**PLANNING APPLICATION NO. 2020/0275**

**LOCATION: UNITED UTILITIES HODDER WORKS, CATLOW ROAD, SLAIDBURN, CLITHERORE, BB7 3AQ**

**PROPOSAL: IMPROVED TREATMENT INCLUDING CONSTRUCTION OF RAPID GRAVITY FILTERS AND ASSOCIATED BUILDING, SECURITY FENCING TOGETHER WITH RE-PROFILING OF AGRICULTURAL LAND USING SURPLUS SOIL.**

I refer to the above application and would like to thank you for the opportunity to provide comment on the proposal. This letter provides Lancashire County Council (LCC) Highways Development Support Teams statutory comments following review of the submitted documentation, including the latest Traffic Management Plan (TMP).

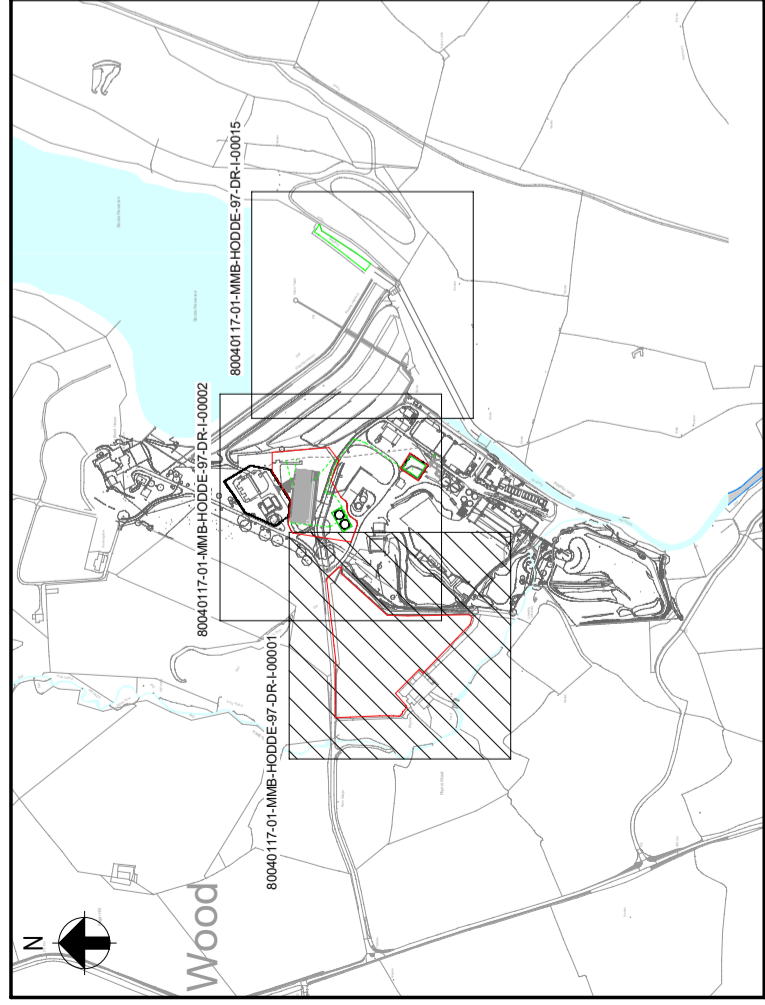
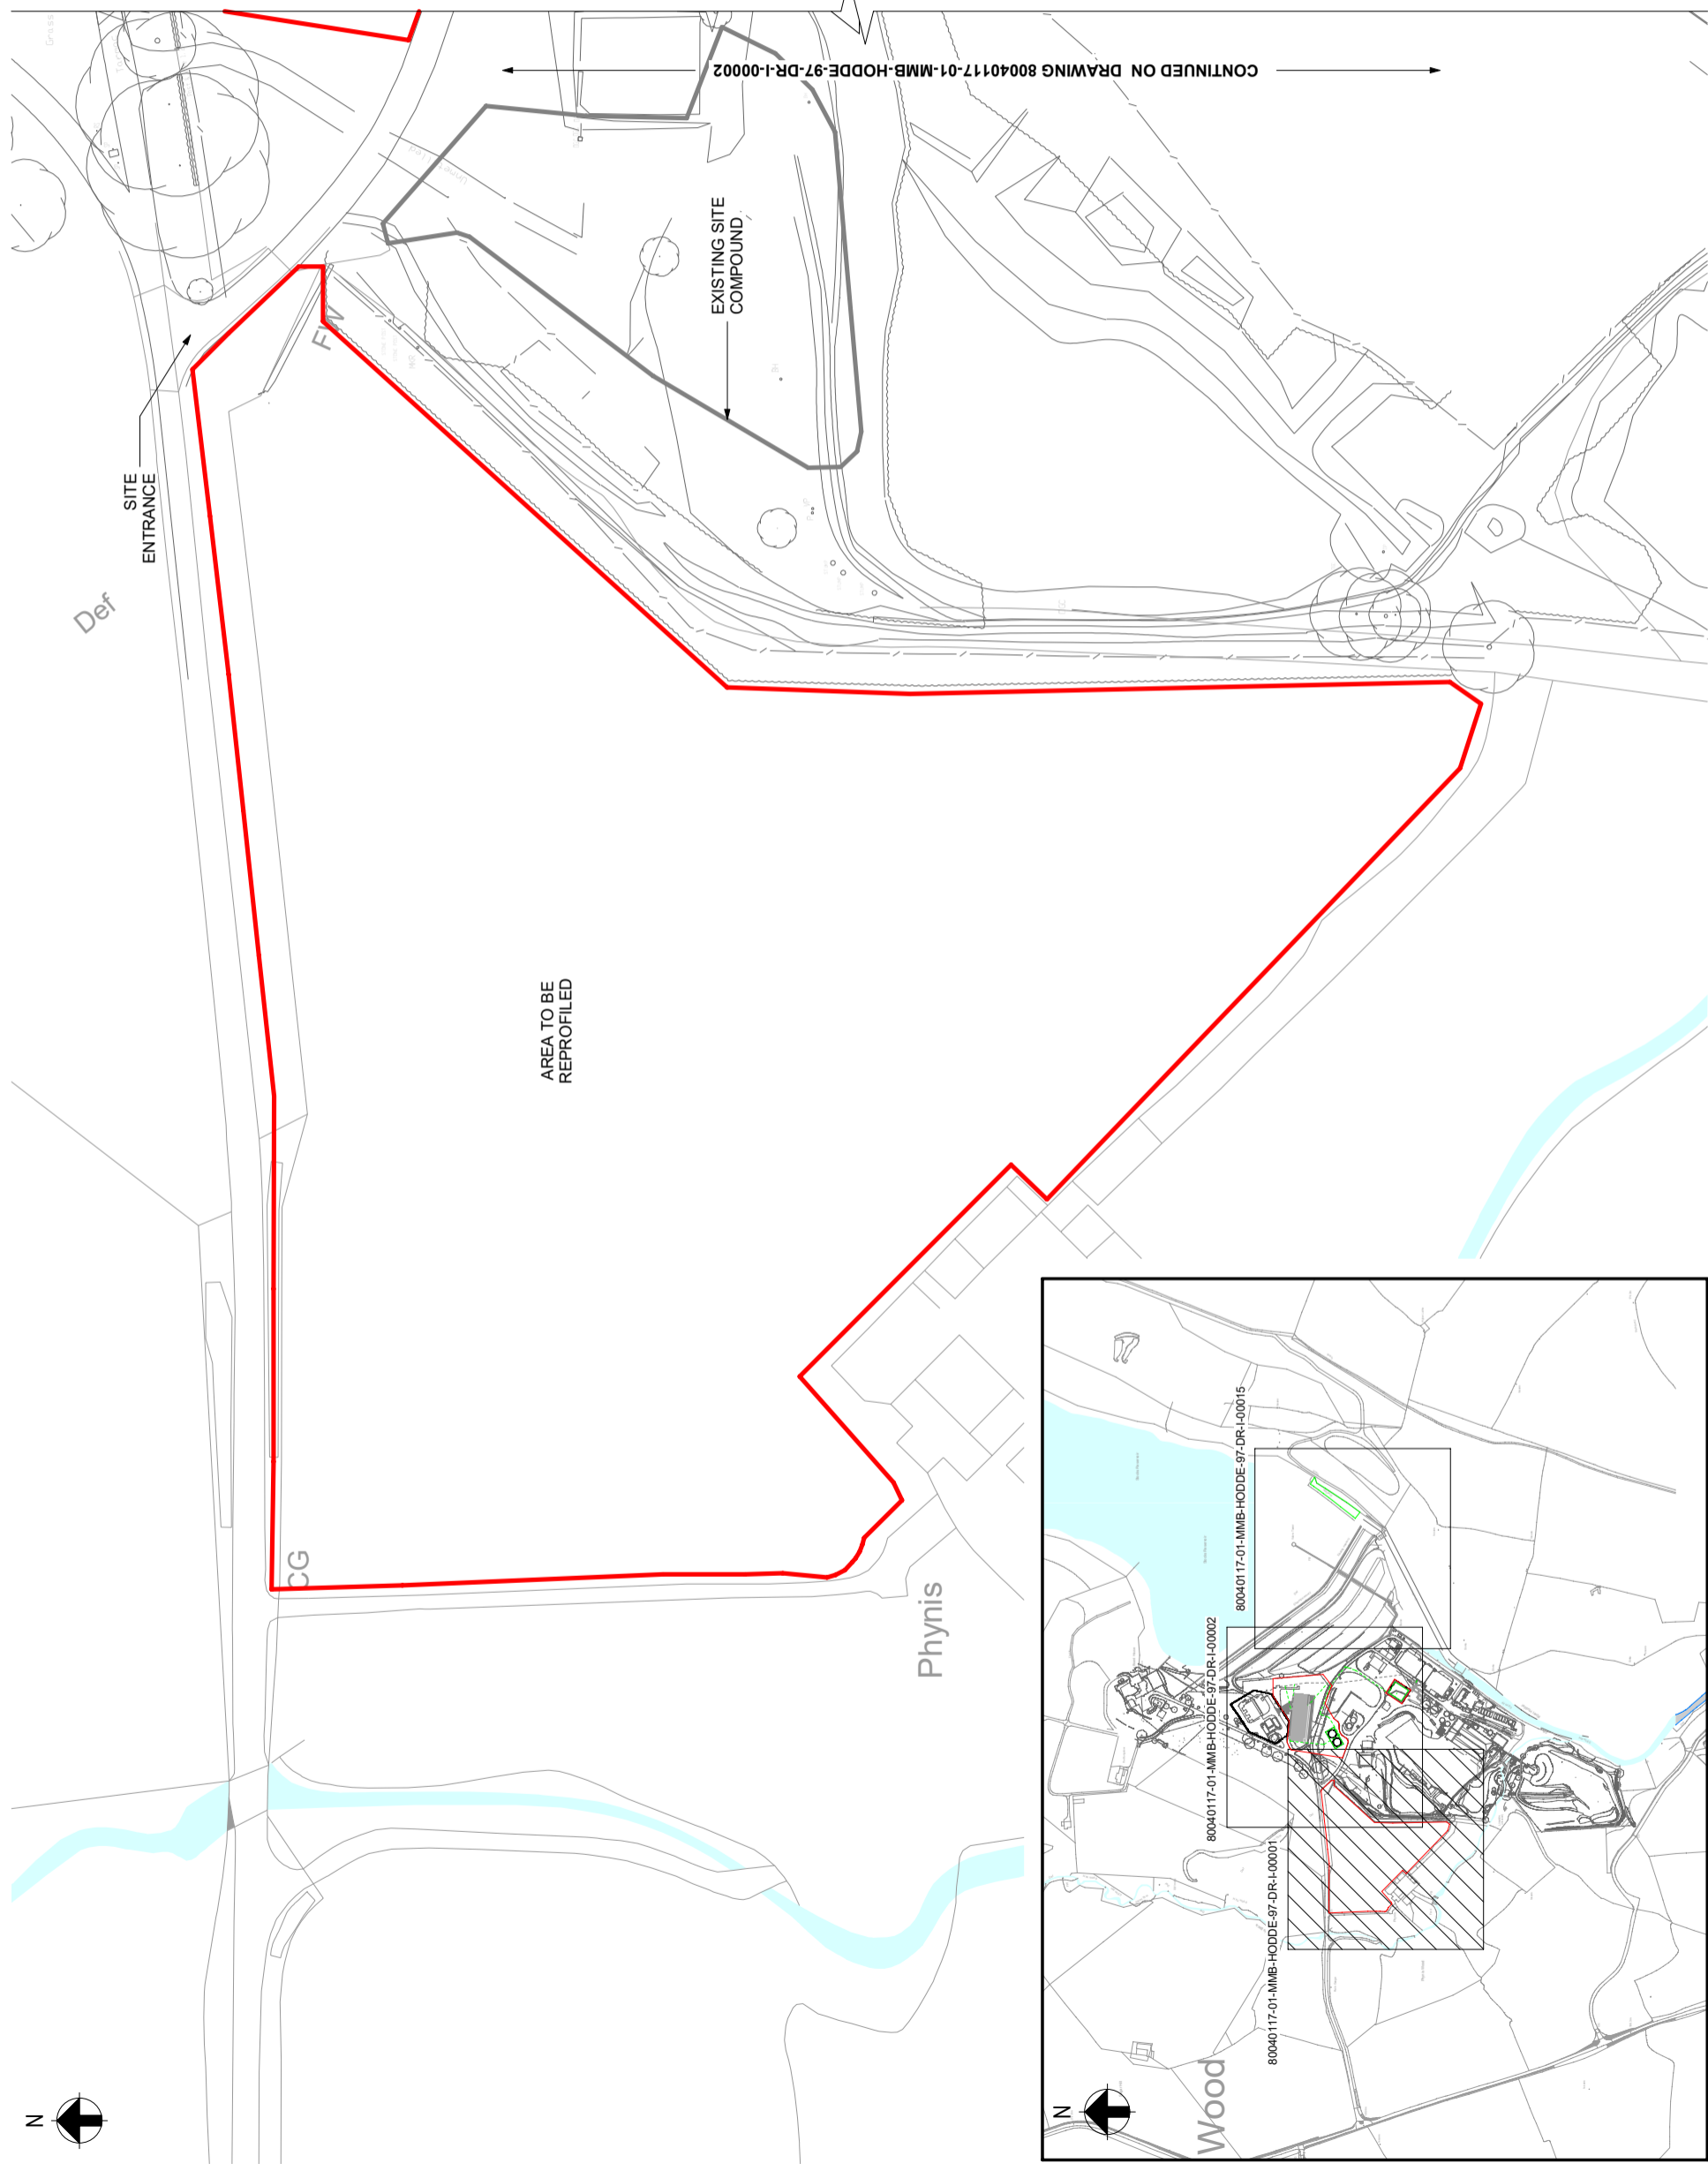
With reference to MMB Plan, Drawing No. 80040117-01-MMB-HODDE-97-DR-I-00004, Revision P03 (dated 5th March 2020), I would make the following comments:

- The layout does not provide a clear first point of arrival, recording of arrivals, security etc.
- There is a need for a clear site arrivals office and a vehicle circulation of the site that supports the measures I consider necessary to comply with requirements to log and keep accurate records of arrival and departure details for HGVs. This is necessary if the use of conditions limiting hourly and daily HGV movements is to be supported. To be clear with consideration for the Traffic Management Report/Plan submitted there are no other acceptable proposals which can demonstrate the level of highway impact from this proposal and the impact on local communities and local amenity.

- LCC Highways are happy to work with the applicant and offer some suggestions where possible.
- In addition, with the layout as shown in the MMB Plan, I consider a further issue that could be expected if not suitably addressed is the waiting of vehicles on carriageway and thus blocking the road for other users that will need to have their access maintained at all times.

- There is also likely to be an issue with mud on the road related to the construction works, I consider wheel wash facilities should be provided and/or continuous road sweeping to maintain a safe access for all users.

- The plans shows a large site office and staff parking compound and also an additional parking/storage area to the eastern end of the works site.
